City of Portland, Maine - Building or Use Permit

Permit No: 04-0384	Date Applied For: 04/08/2004	CBL: 333 E029001
------------------------------	--	----------------------------

Location of Construction: 138 Milton St	Owner Name: Grassi Richard & Vicki Jts	Owner Address: 138 Milton St	Phone:
Business Name:	Contractor Name: David Dipietro	Contractor Address: 221 Virginia Street Portland	Phone (207) 797-9531
Lessee/Buyer's Name	Phone:	Permit Type: Change of Use Home Occupation

Single Family w/home occupation: add 352 sq ft 1 story addition for hair salon	SFR w/home occupation: add 352 sq ft 1 story addition for hair salon
--	--

PROJECT NAME:		GRASSI ADDITION PORTLAND, MAINE	
DRAWING NAME:		FLOOR PLAN	
SCALE:	1/4" = 1'-0"	DRAWN BY:	JEFF S. GIGGEY
DATE:	4/02/04	DWG. NO.:	102

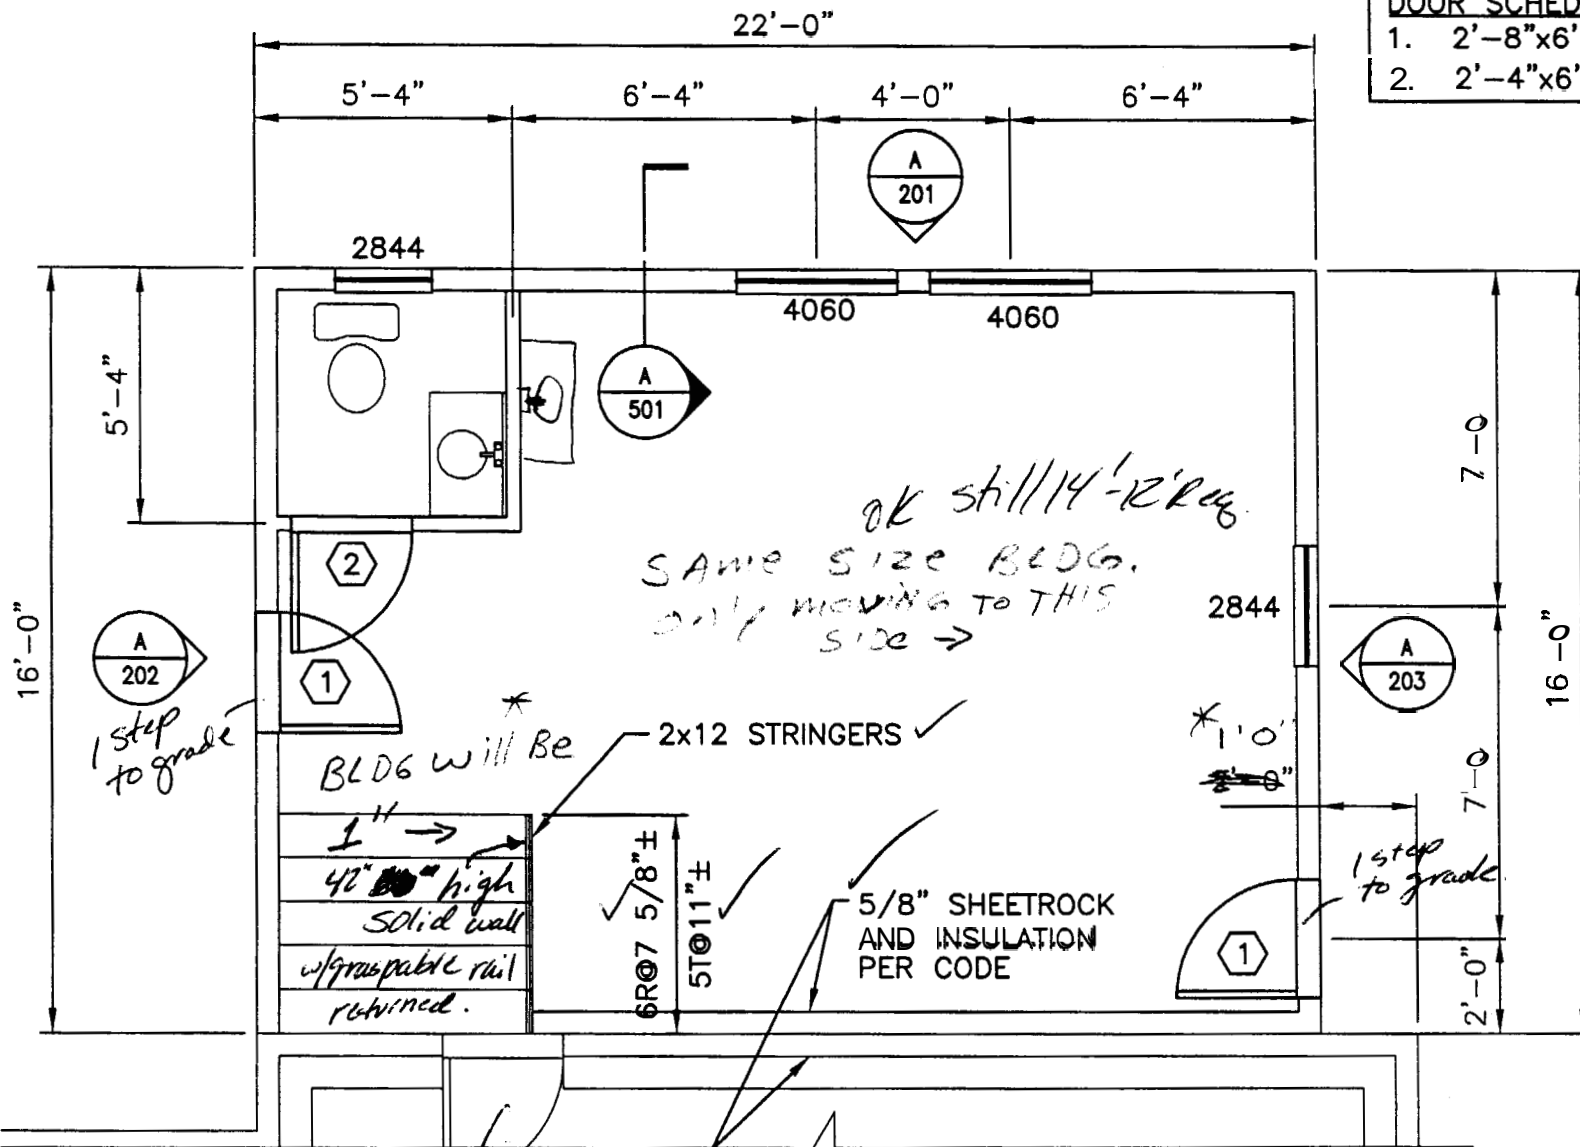
Comments:
4/27/2004-tmm: need guardrail detail and door between garage and addition - spoke w/owner - went over items and noted each on permit - ok to issue
